Conservation Officer – In response to consultation on original application stated: The main issue to be considered from a heritage perspective in the determination of this Listed Building Consent application is: -

The application seeks permission to alter some existing office spaces within Wentworth Castle (Northern College), within the Cutler Wing. The rooms were once bedrooms. The Cutler Wing is the earliest extant section of the house being built in 1670. The house and the wider landscape are listed grade 1 and of exceptional historic significance due to their architectural, historic and communal values. The rooms in question retain a good degree of historic detailing and mouldings including decorative architraves, cornice, friezes and fireplace surrounds. The decoration of the room intended to become teaching space C2 appears consistent with the late C17 date of the Cutler Wing. The room to become teaching room C3 is a little different in terms of its decoration and appears more classical, less floral and more restrained and may be a later alteration (of the decoration)

The proposal includes removal of existing modern partitions, reinstating the original form of the two forme

Revision	
Project	Teaching Space +
Address	Wentworth Castle, Stainsborough, Barnsley
Client	The Northern College
Drawing	Door Details

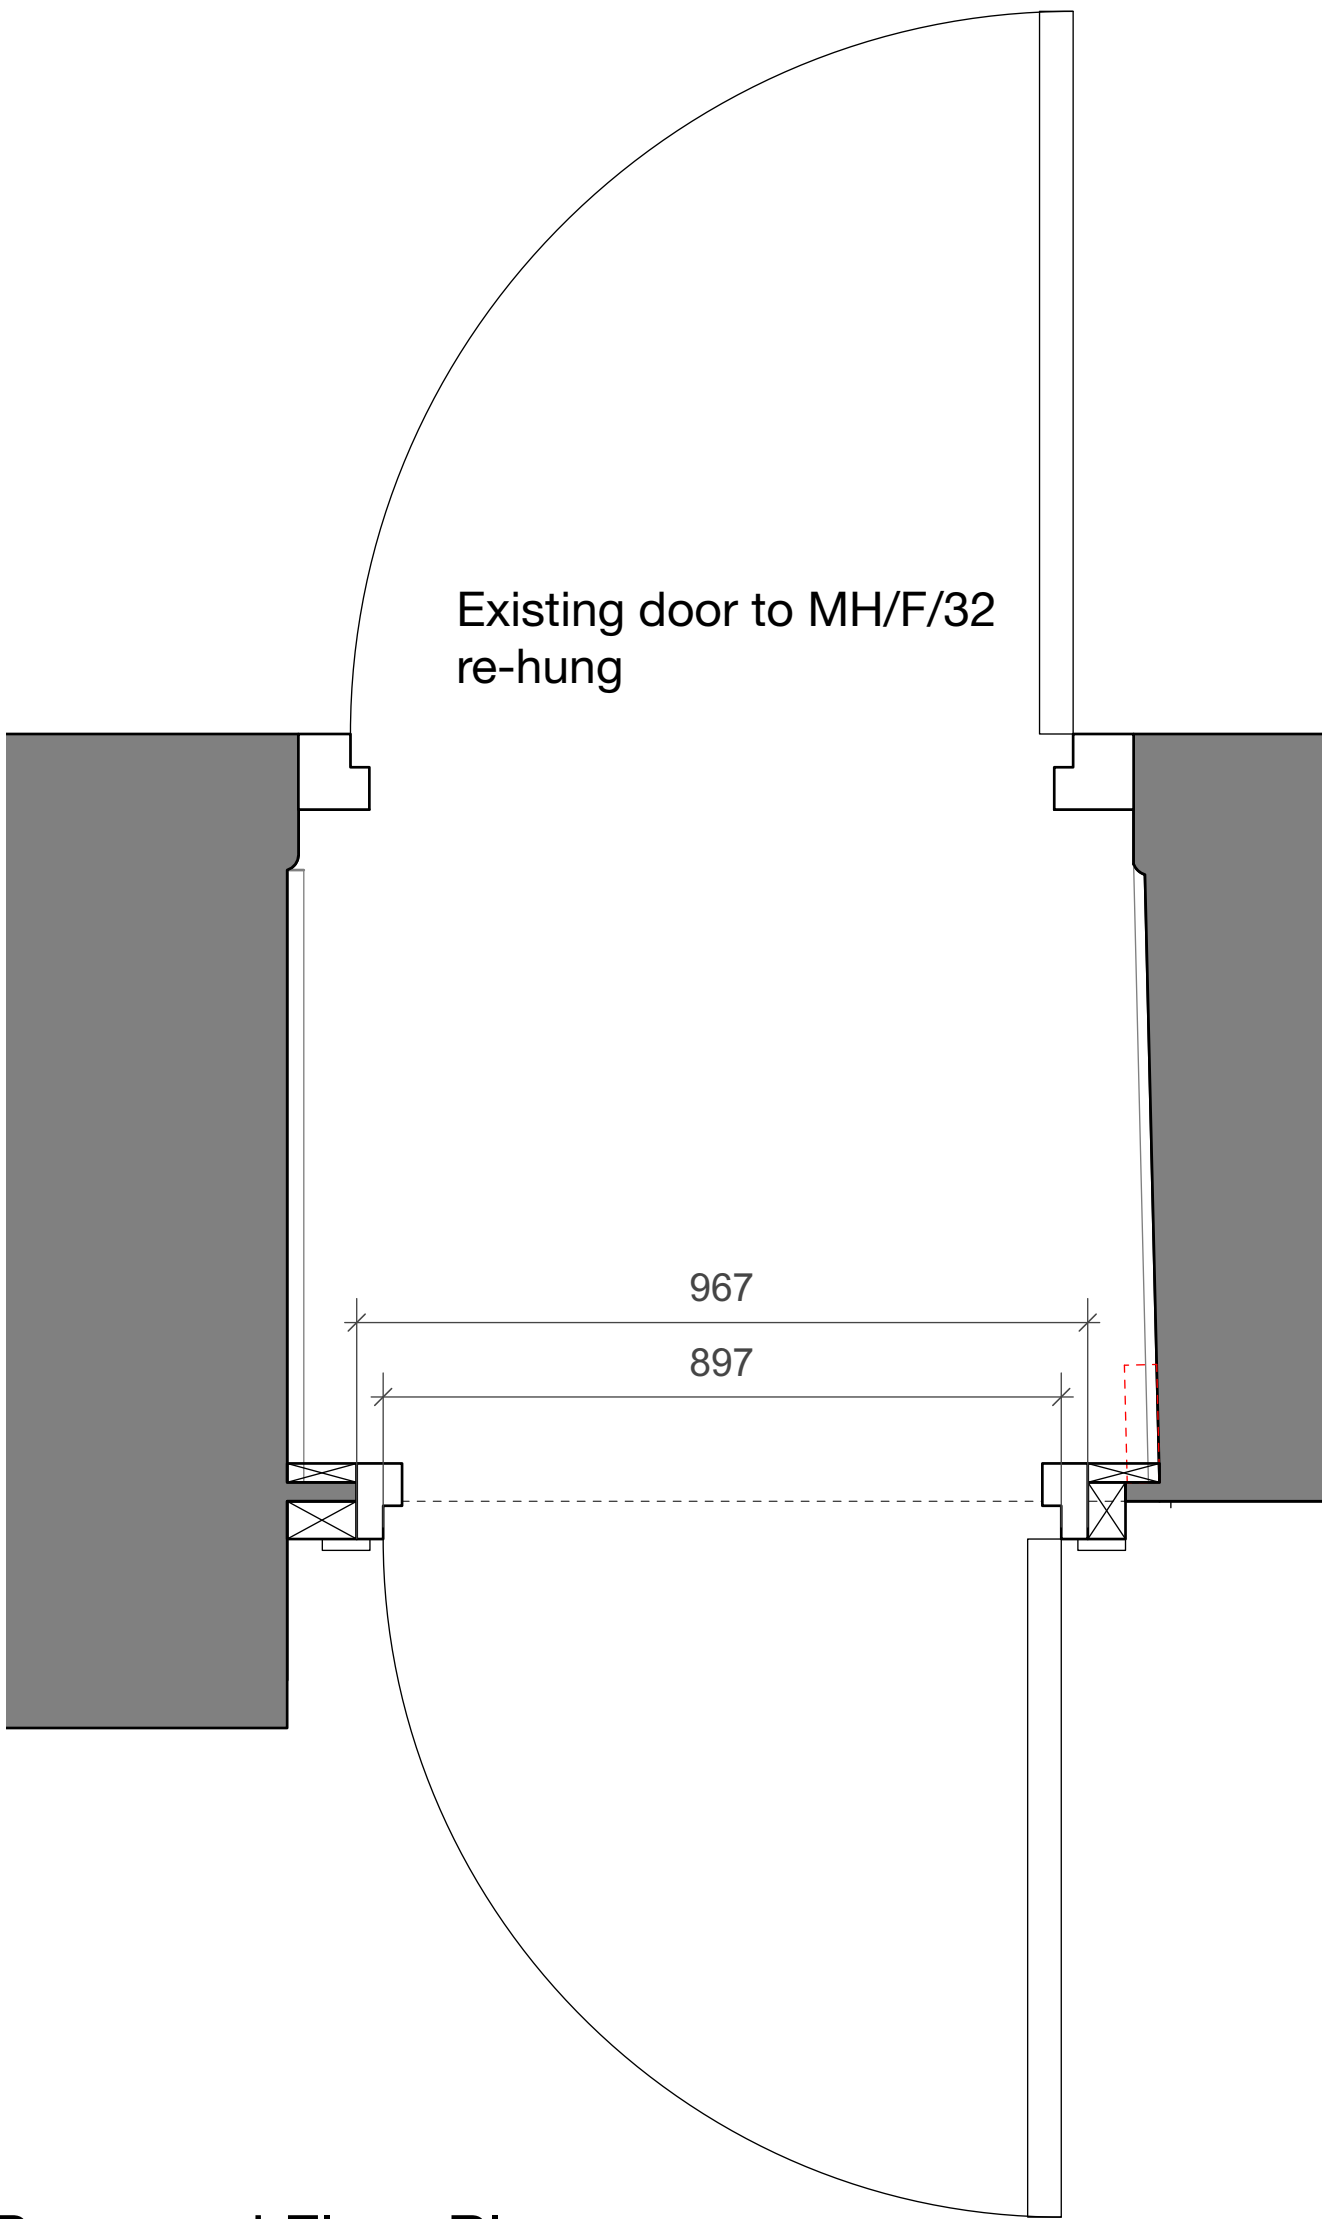
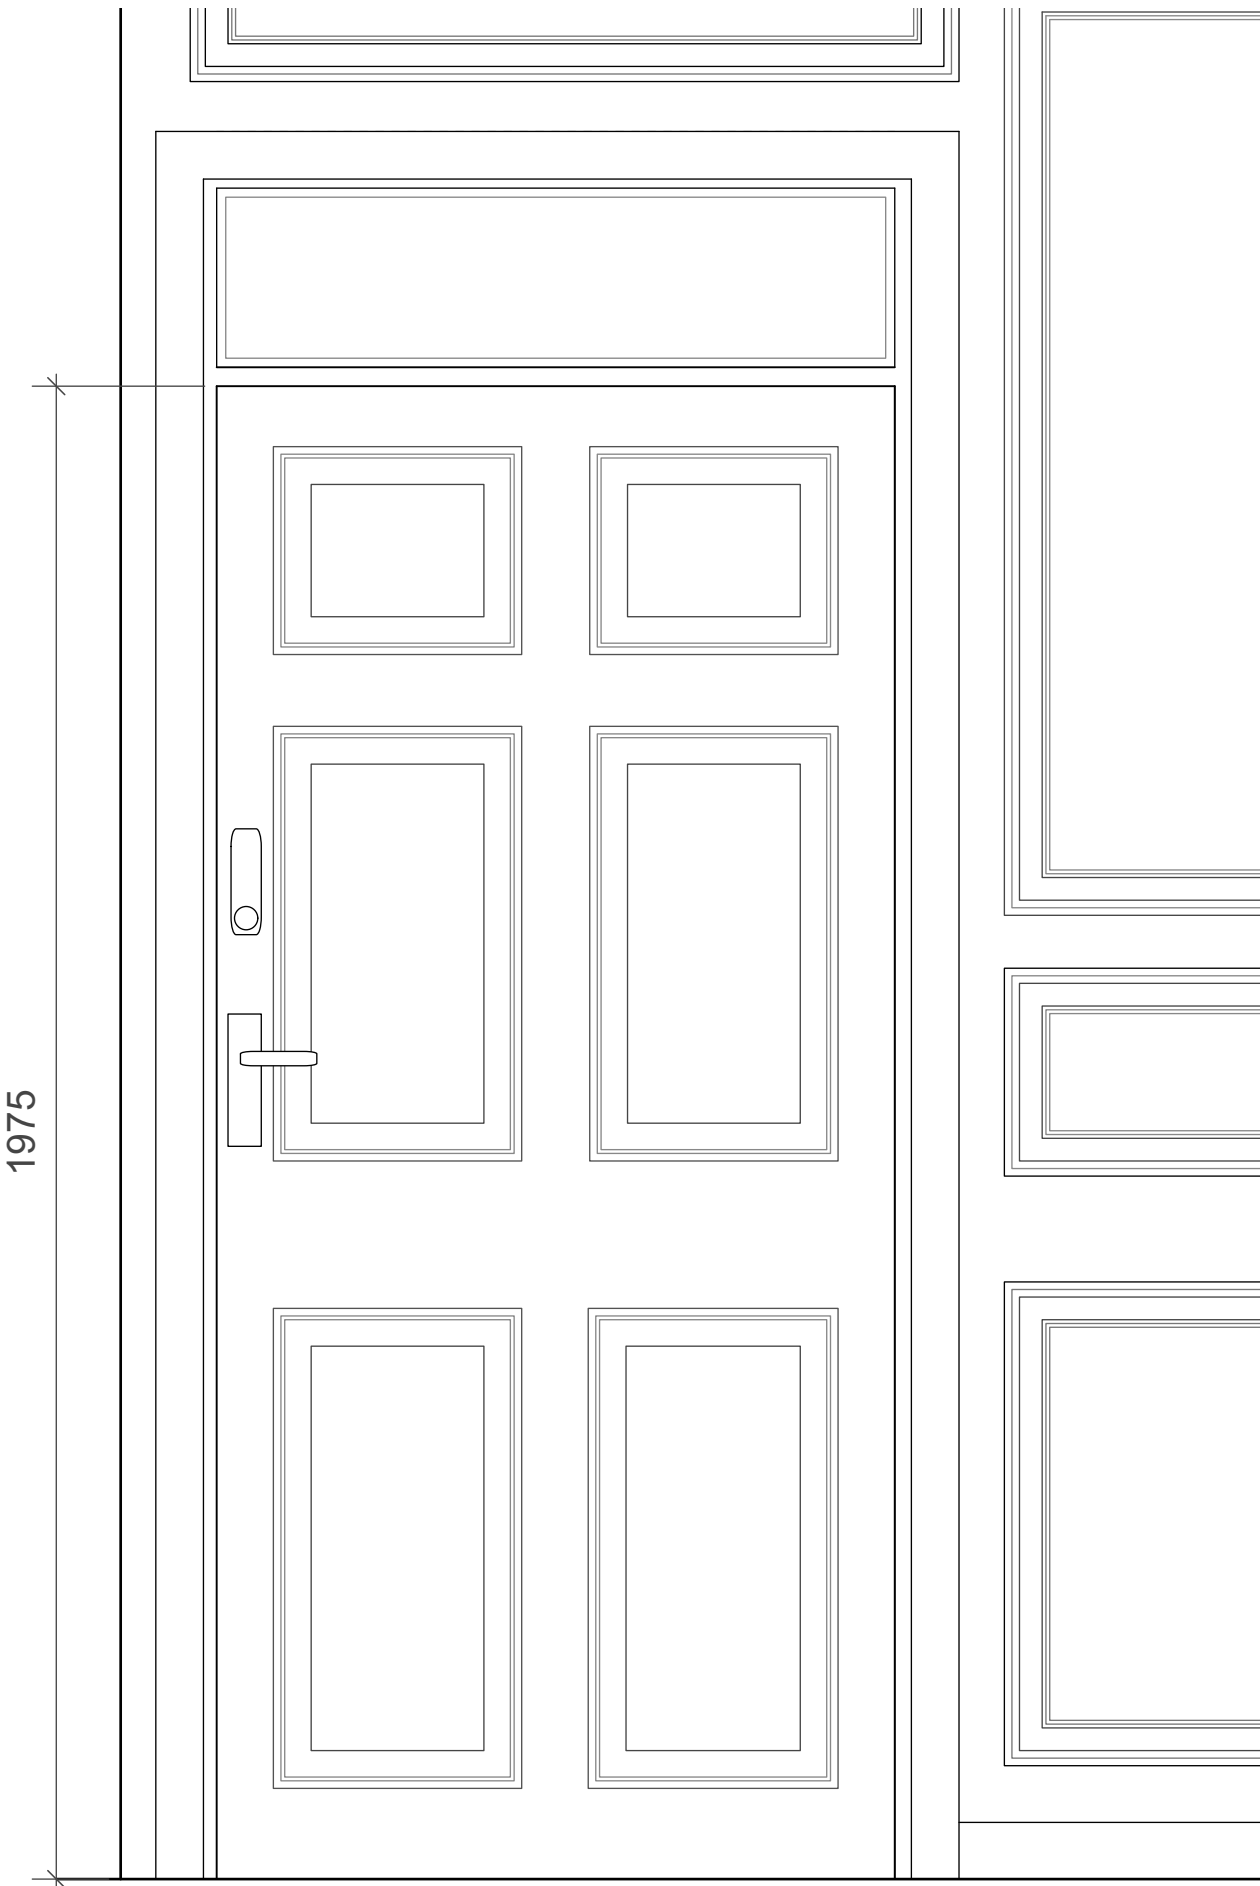
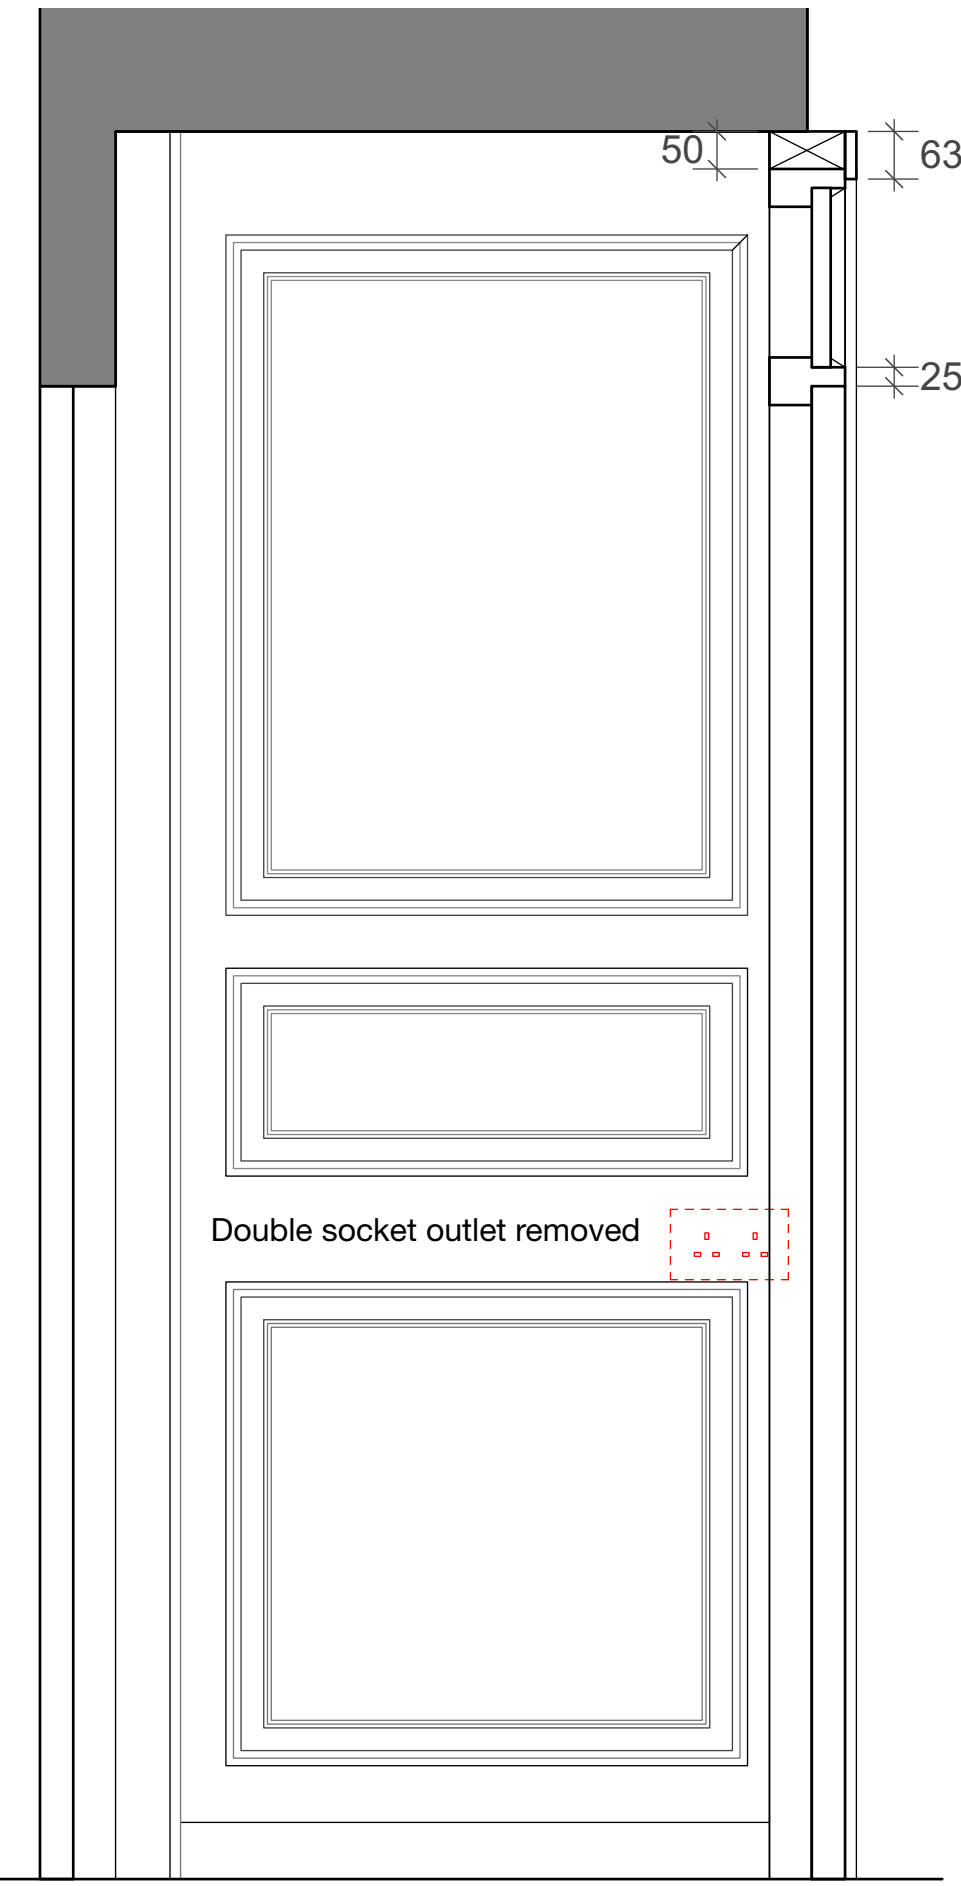
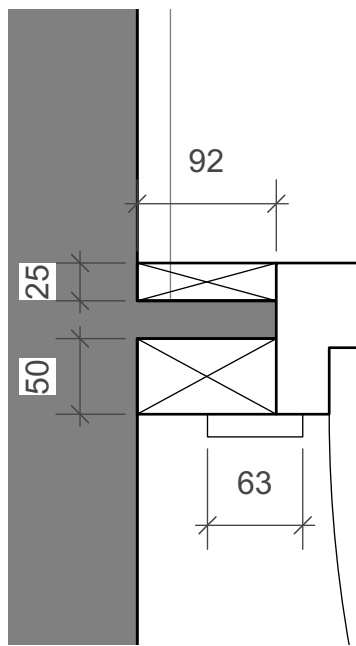
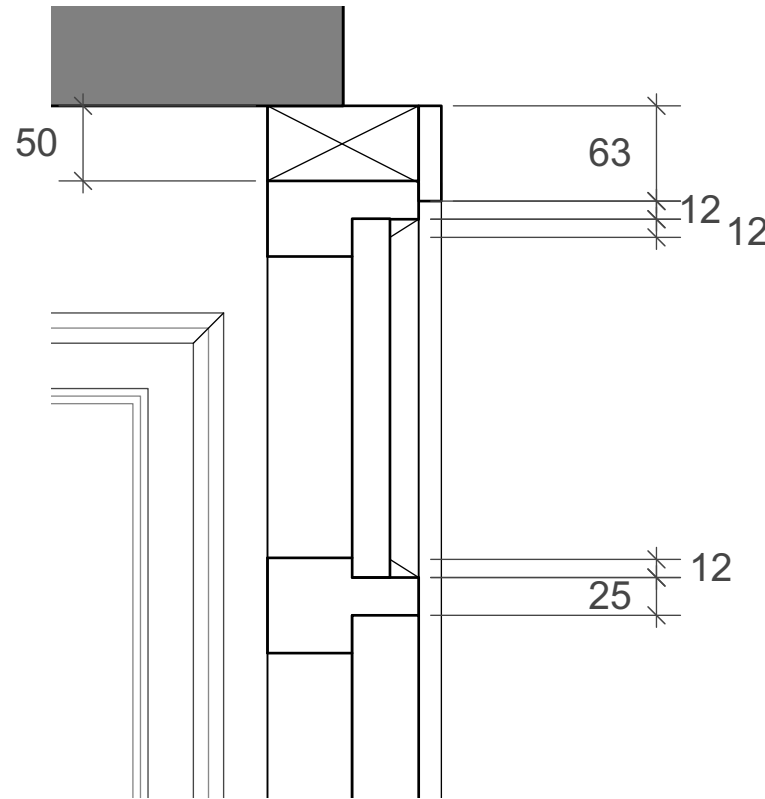
In response to the submission of details of the new interior door, confirmed that these details are supported.

The proposal includes the addition of a further door to create a cupboard between the new classrooms. A detailed drawing has been submitted which shows that the door will match the existing door to the new cupboard, the agent clarifies that there will be no loss of the original joinery features, and the Conservation Officer has confirmed that these details are acceptable.
